Subject: FW: S278 changes A/113/19/DOC Condition 8

A/113/19/DOC Condition 8

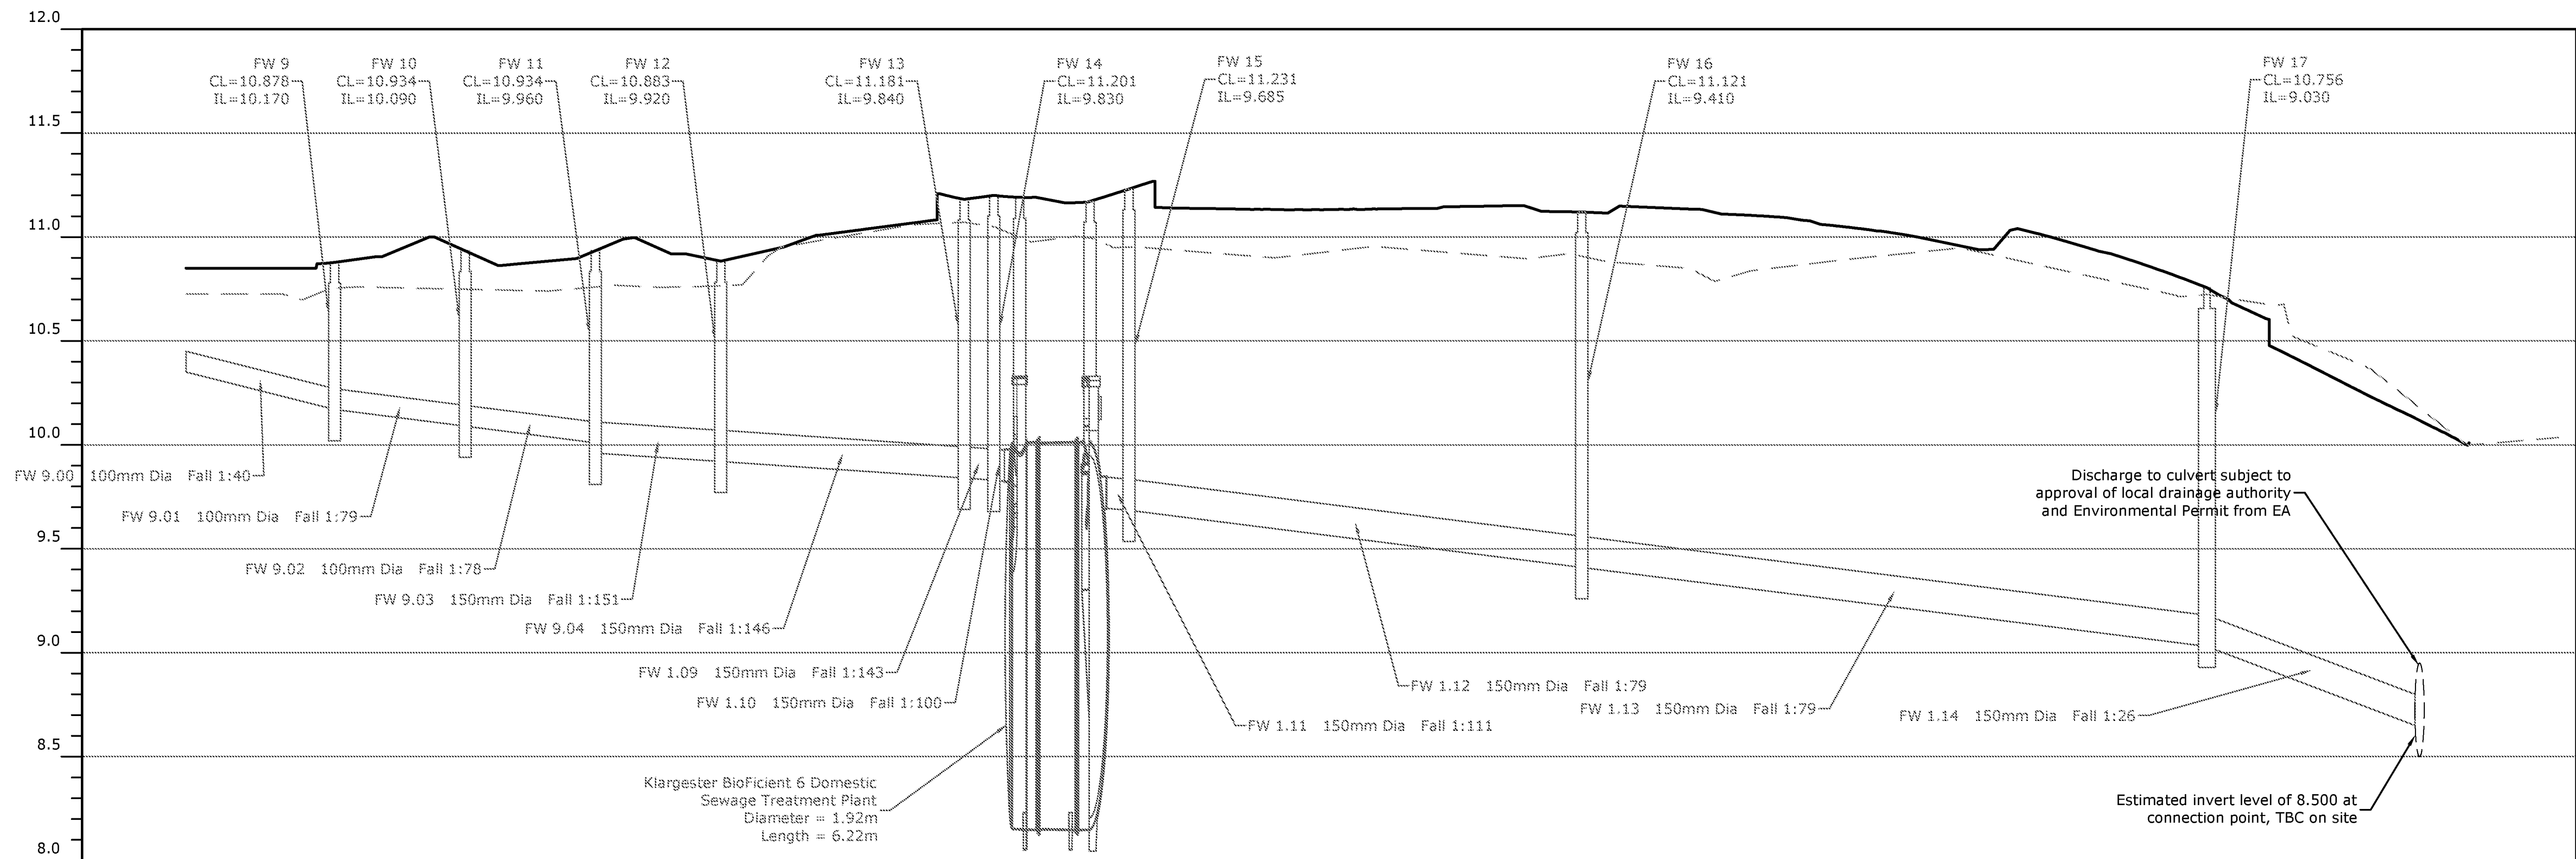
Sorry for the delay, I'm currently unwell and I'm off work at the moment. On the attached, I will be satisfied if everything inside the light blue box can be changed to light Gray colours as it is not part of the S278 work but keep the gully connection as shown and show this as blue. (also update the key))

Remove the construction key as we discussed and change the kerb colours to black.

Thank you for your mark-up. Please find enclosed the updated drawings, we trust you are able to issue the S278 consent.

Regarding the "gully connection" you reference (I assume you don't mean the existing gullies). This is not a gully, but the manhole connection from the sewage treatment plant to the culvert. Therefore it is to remain private and we have not shown it in blue.
